From: Jonathan Best <Jonathan.Best@arun.gov.uk>
Sent: 10 July 2026 14:03
To: Planning.Responses <Planning.Responses@arun.gov.uk>
Cc: Amber Willard <Amber.Willard@arun.gov.uk>
Subject: BR/82/26/PL

63 Annandale Avenue Bognor Regis PO21 2ET.

I have reviewed this application with regards to ecology and Biodiversity Net Gain.

| DRAWING<br>Proposed<br>Block Plan         |                  |

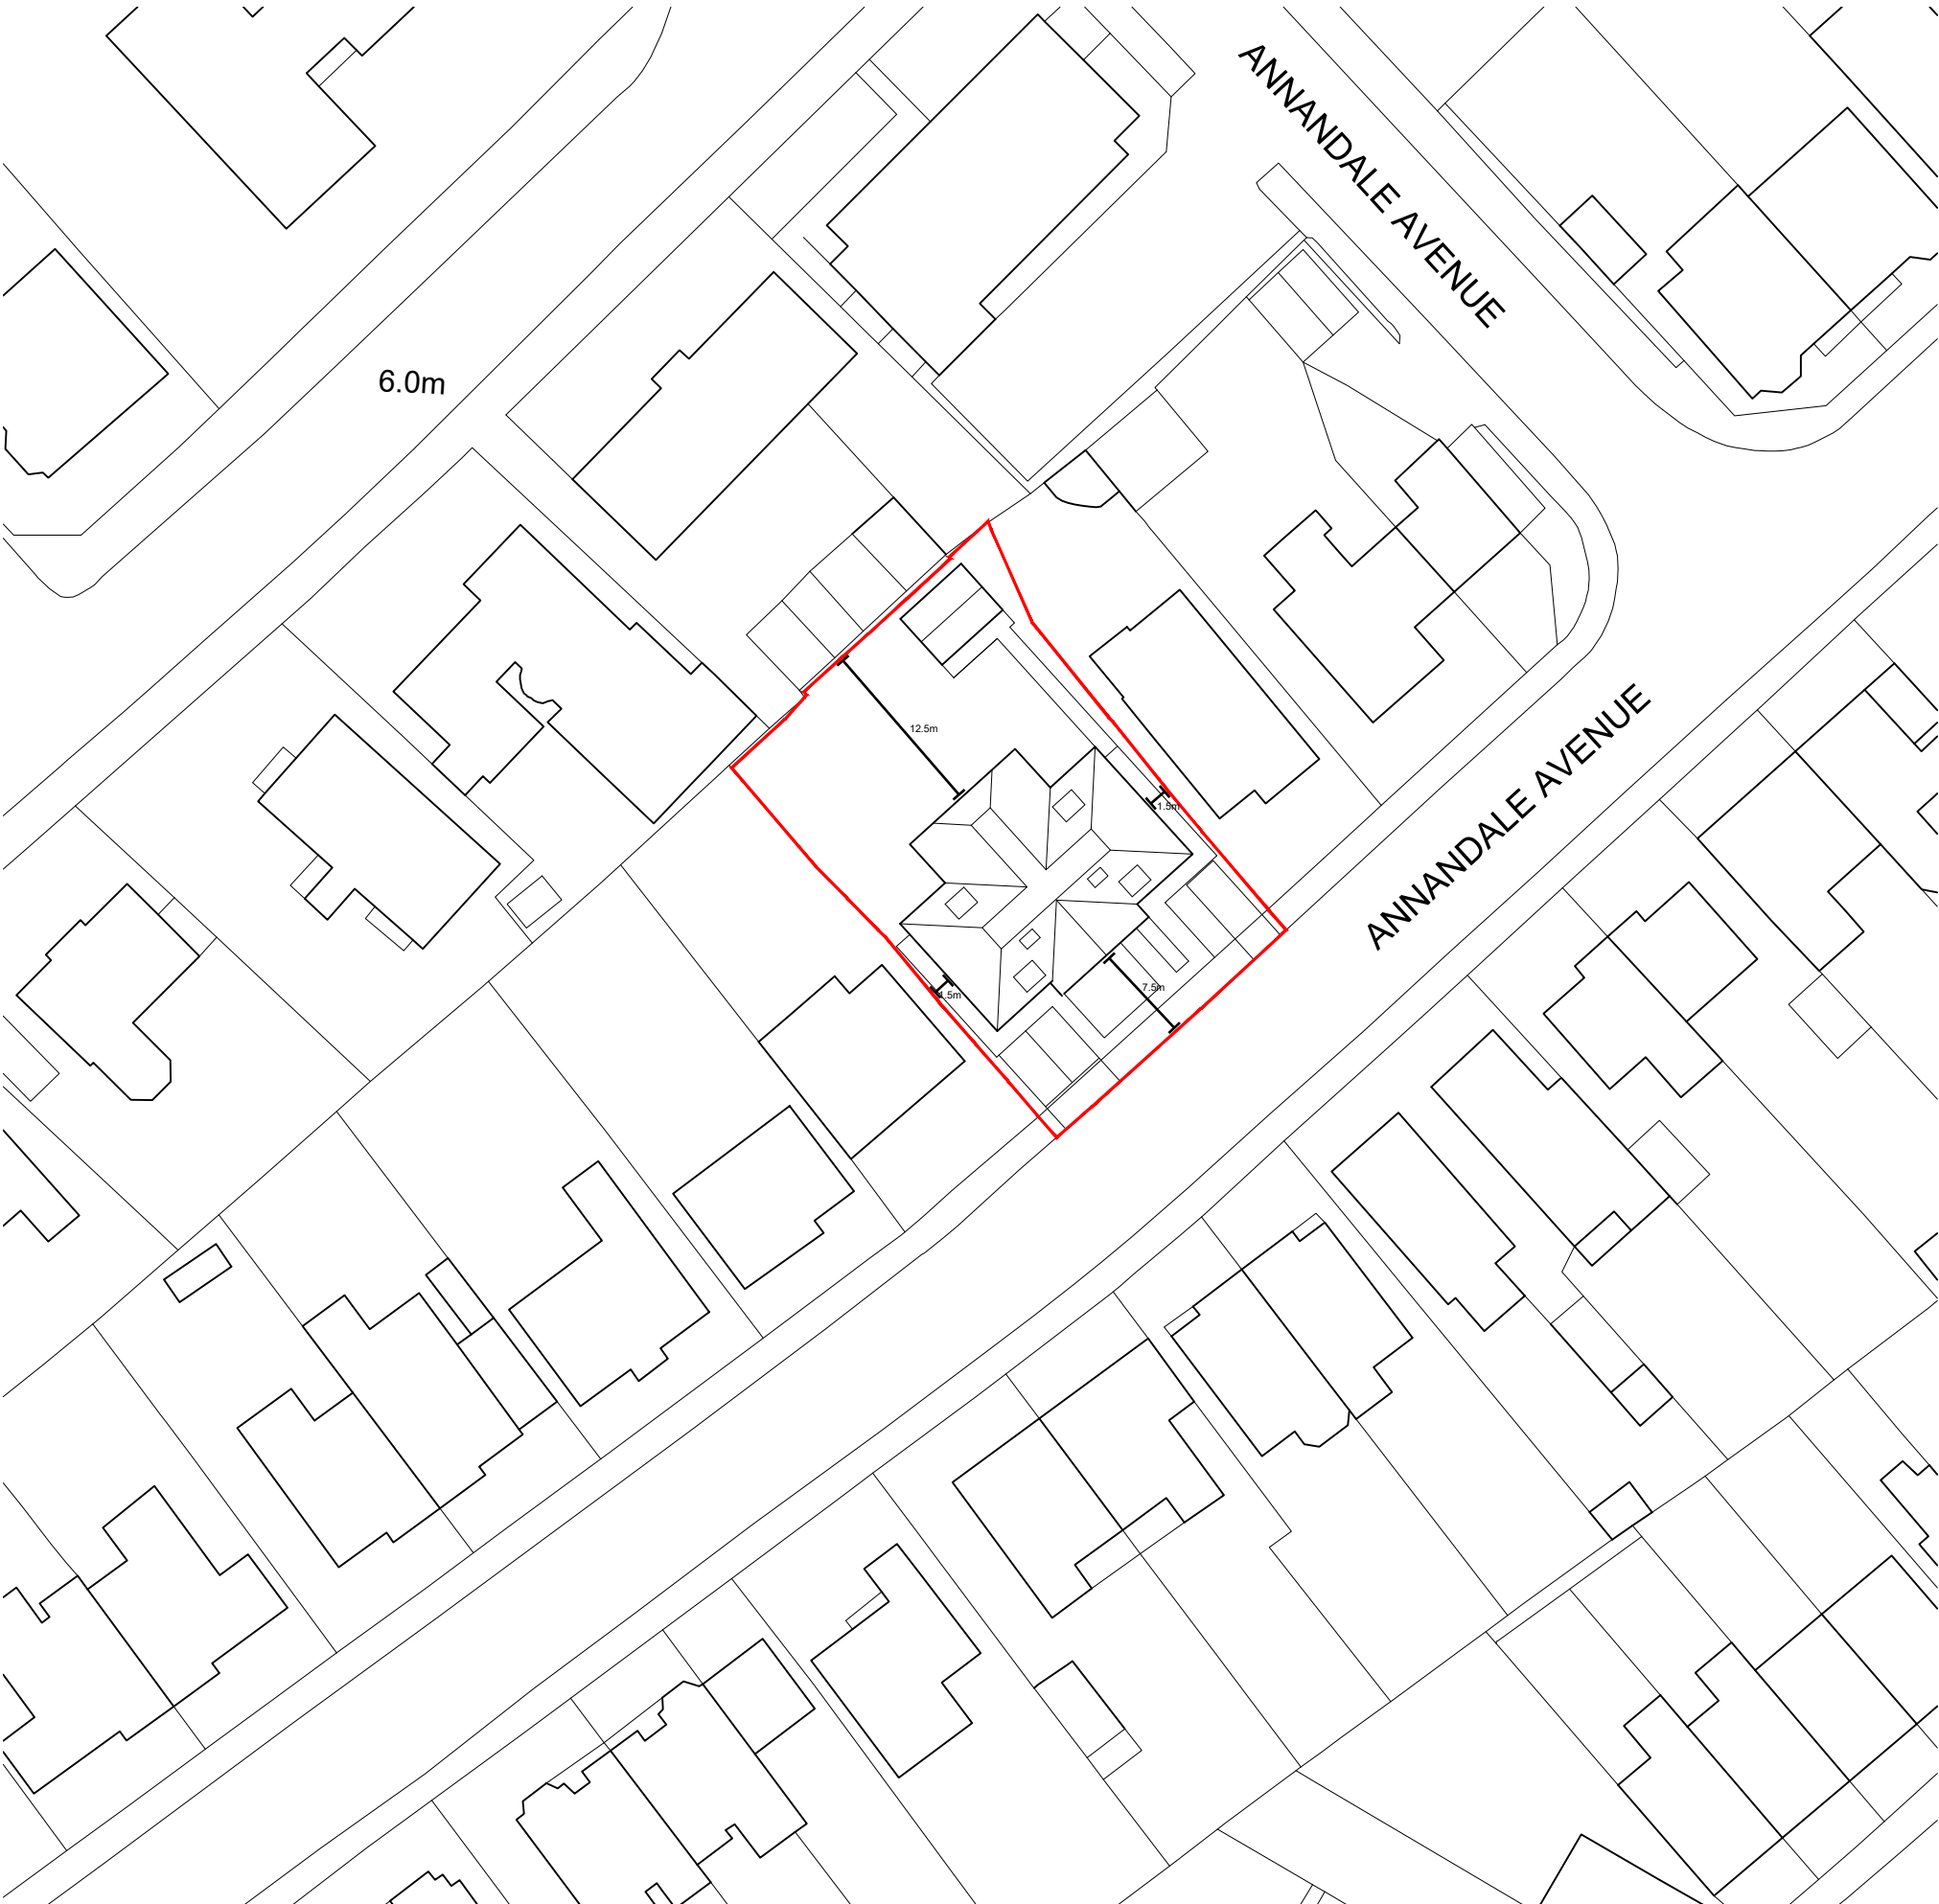
The PEA habitat plans show Modified Grassland, Sparsely vegetated urban land and non-native hedge present on the site.

The proposed plans suggest these habitats would be impacted by the development. The habitat present is over 5m sq. If more than 5m Sq. is being impacted statutory BNG would apply to this application. Clarification on this is required prior to determination.
